From: [REDACTED]
Sent: 18 February 2015 16:37
To: Anita Gardner
Subject: Re: FG/20/15/DOC - Balcony screening 9 Marine Drive, Ferring

From: Anita Gardner
To: [REDACTED]
Sent: Thursday, February 12, 2015 3:35 PM
Subject: FG/20/15/DOC - Balcony screening 9 Marine Drive, Ferring

1008 SK14A
West Elevation
Ferring Marine
Scale 1:50

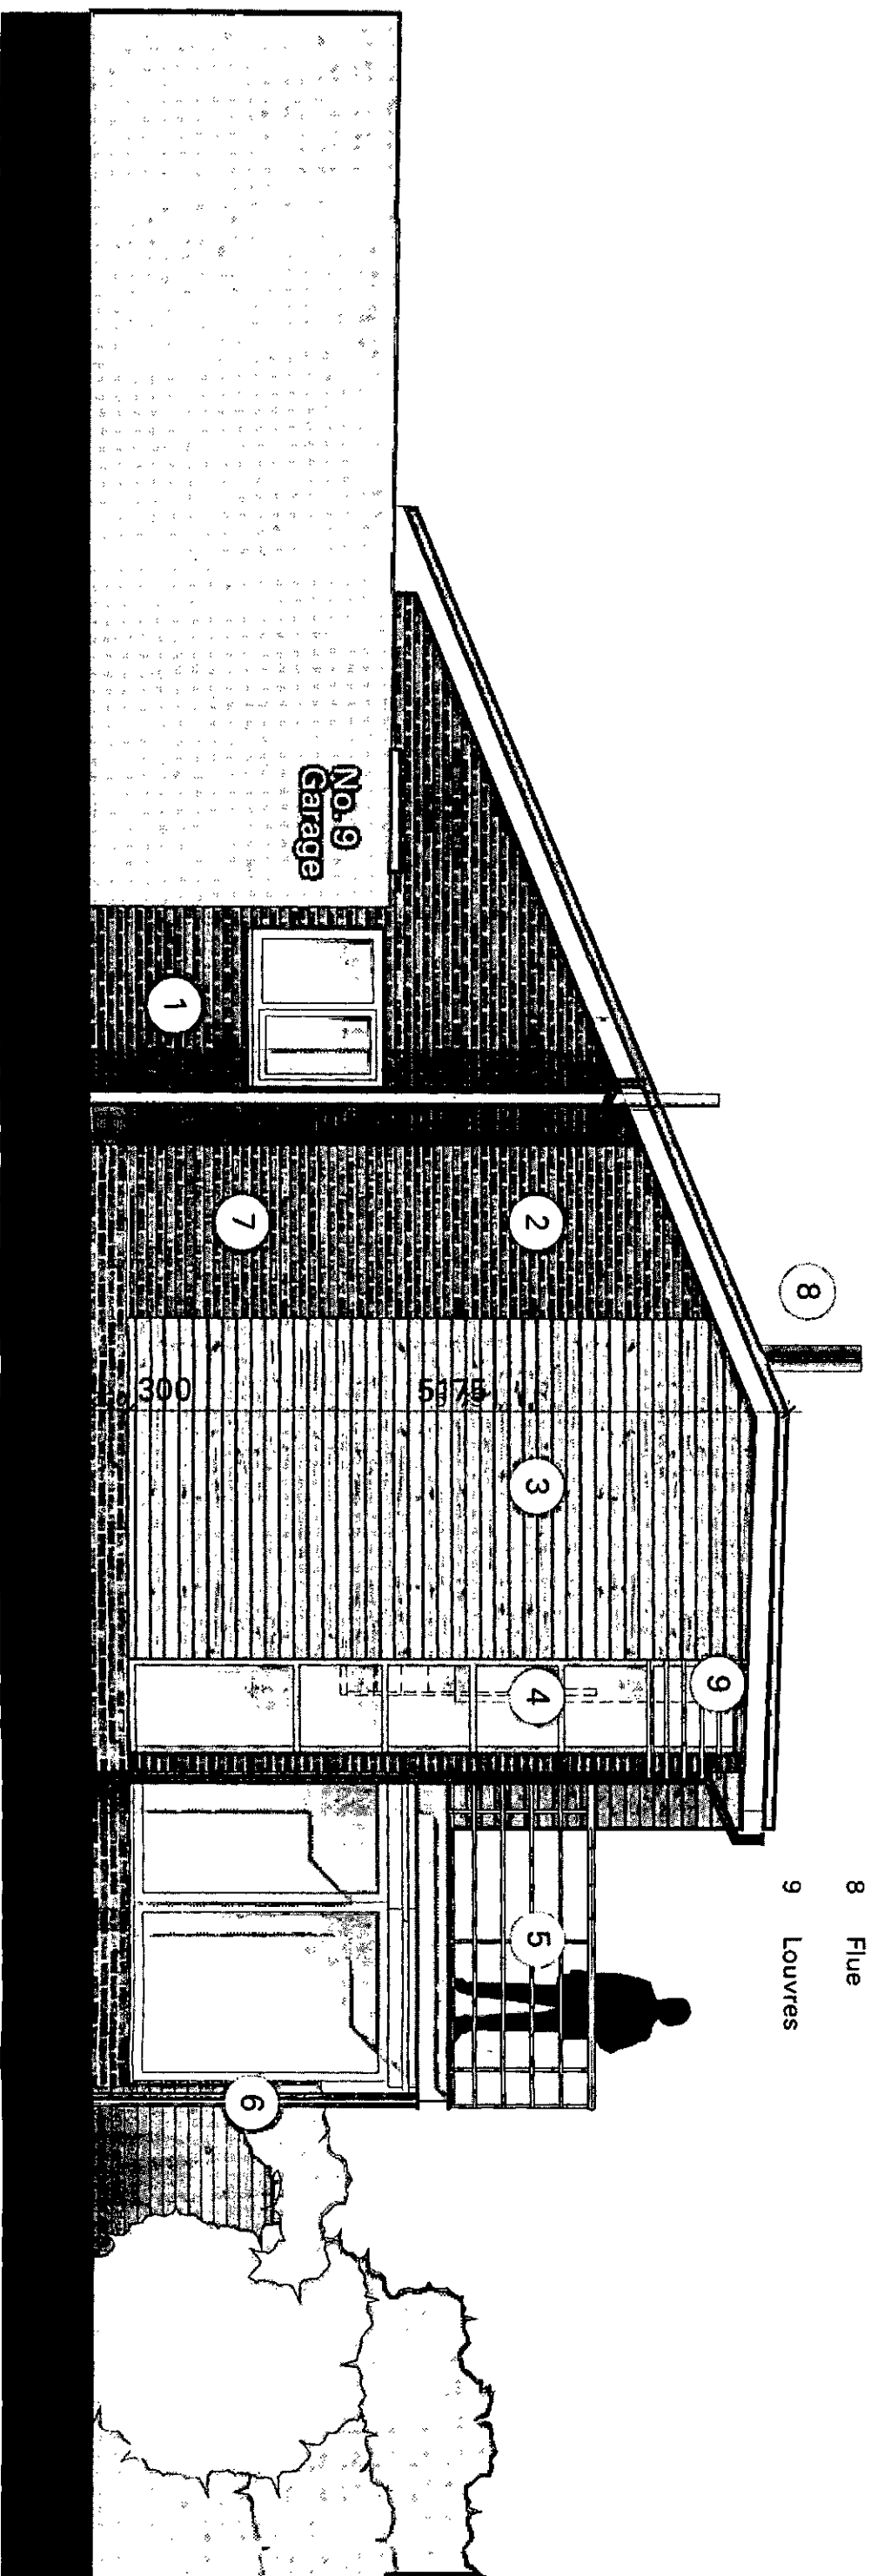
I refer to the above application. The details submitted are not acceptable. The balcony ends would need to be screened with 'obscure' glazing, not opaque and the screening would need to extend the depth of the balcony at a height of 1.8m as stated in the condition, not just a 0.3m depth.
